PLANNING CONSULTATION RESPONSE

Application No	2026/0420
Proposal	Erection of 10no. 2 and 3 storey detached dwellings
Address	Land west of Sheffield Road, Birdwell, Barnsley
Date of Consultation Reply	28/07/2026
Consultee	Pollution Control

Consultation Assessment and Justification

50.0 <= ... < 52.5
52.5 <= ... < 55.0
55.0 <= ... < 57.5
57.5 <= ... < 60.0
60.0 <= ... < 62.5
62.5 <= ... < 65.0
65.0 <= ... < 67.5
67.5 <= ... < 70.0
70.0 <= ... < 72.5
72.5 <= ...

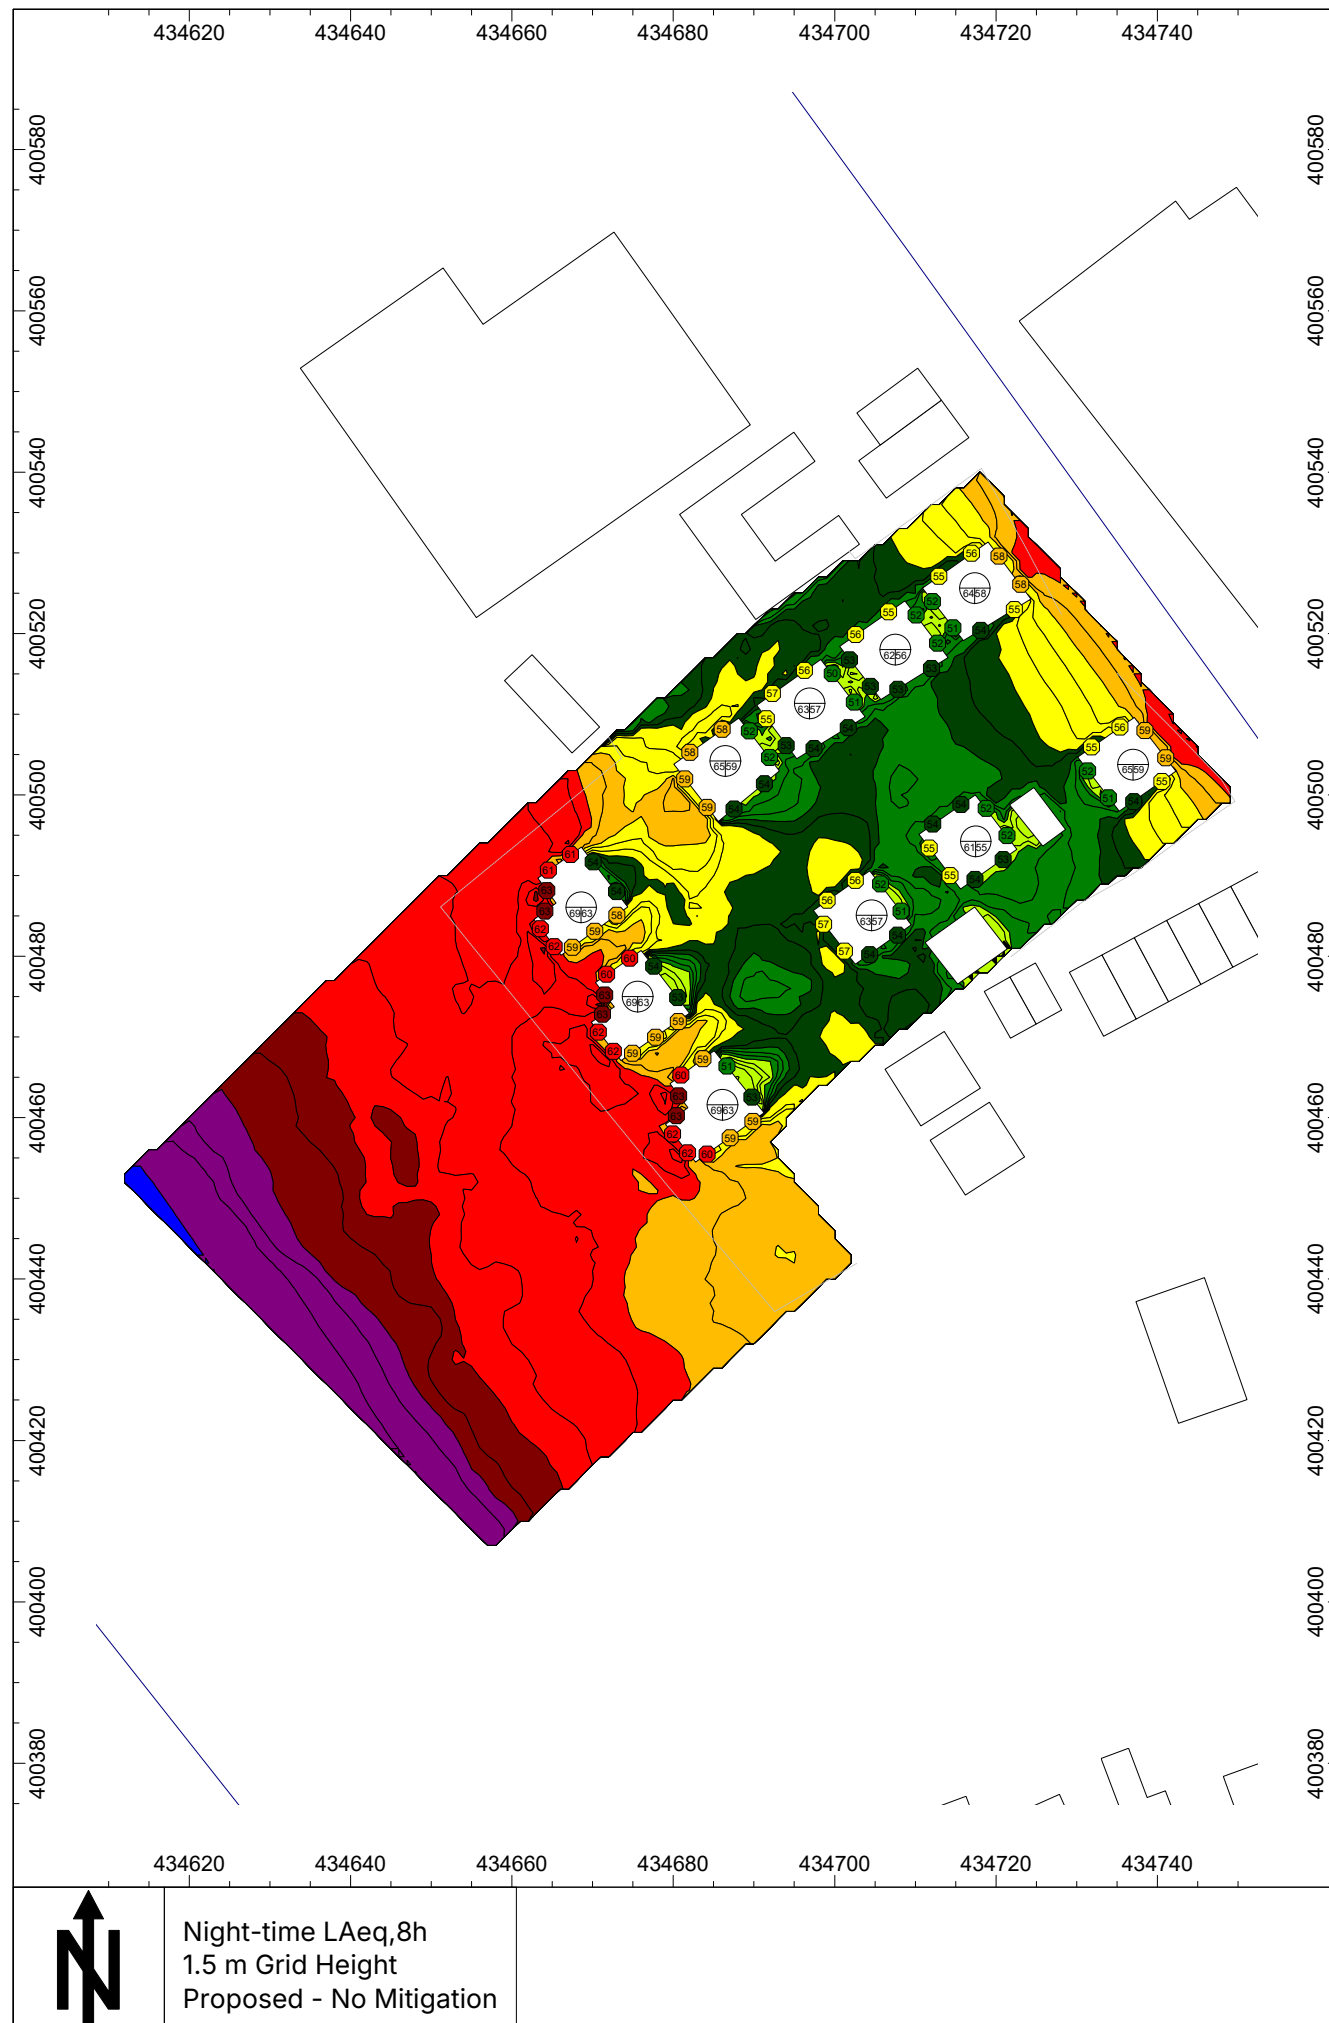
- The modelling in Appendix B appears to show daytime noise levels in the outdoor amenity areas closest to the M1 to be 55dB to 65dB LAeq, 16h, with mitigation. Yet the report states that with mitigation "daytime noise levels within the majority of the proposed gardens are predicted to be approximately 55dB LAeq, 16 hr or below". Further clarity on the noise levels in the outdoor amenity spaces is required.
